Application number: 2020/93007	
What is the application for?:	Change of use of former public conveniences to Class E retail shop with erection
Address of the site or building:	former Public Conveniences, Westbourne Road, Marsh, Huddersfield, HD1 4LF
Postcode:	WF15 8HG

User comments

Proposed Site Plan
Scale: 1 : 200

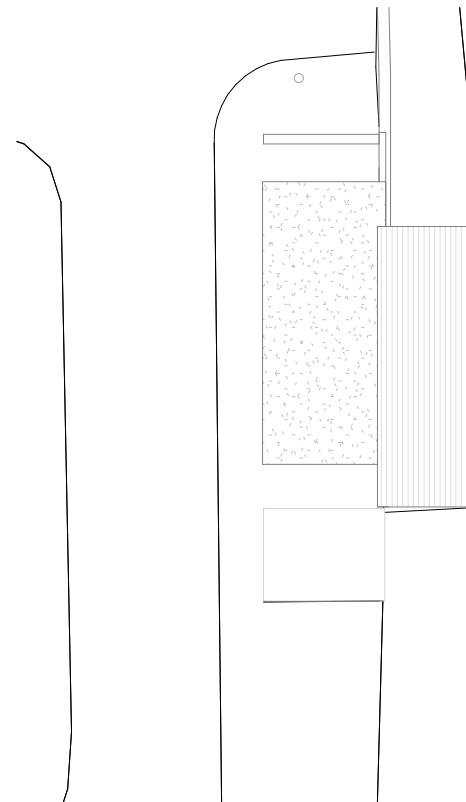
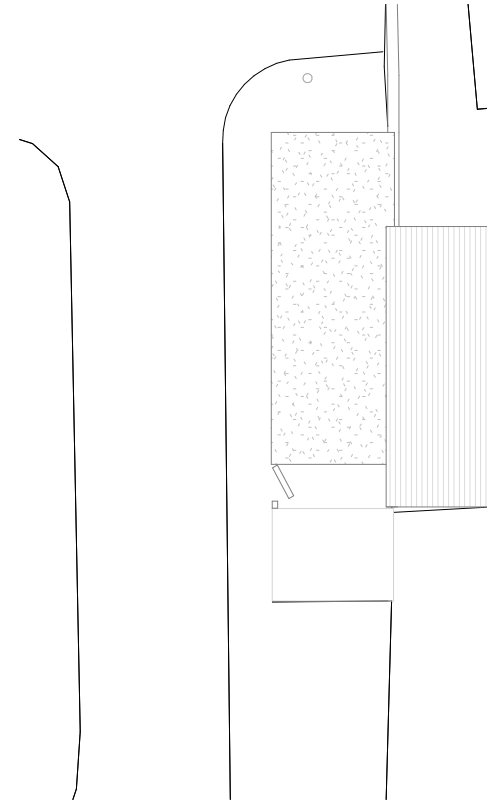
Type of comment: A general comment
<p>We are happy with the proposed redevelopment of the site with a single storey retail building. However</p> <ol style="list-style-type: none">1. Who owns the land where they are planning to extend towards the telegraph pole?2. There should be no change to access on the road and pavements in front of the new development.3. The car park at the rear is not a public car park. The owners of the new building should be required to provide a dedicated car parking space.4. The new building should have a restriction placed on it saying that it cannot be converted to a hot food takeaway.5. The proposed permitted opening hours seem rather strange - 05:00 to 16:00? Why do they need to open at 5am?
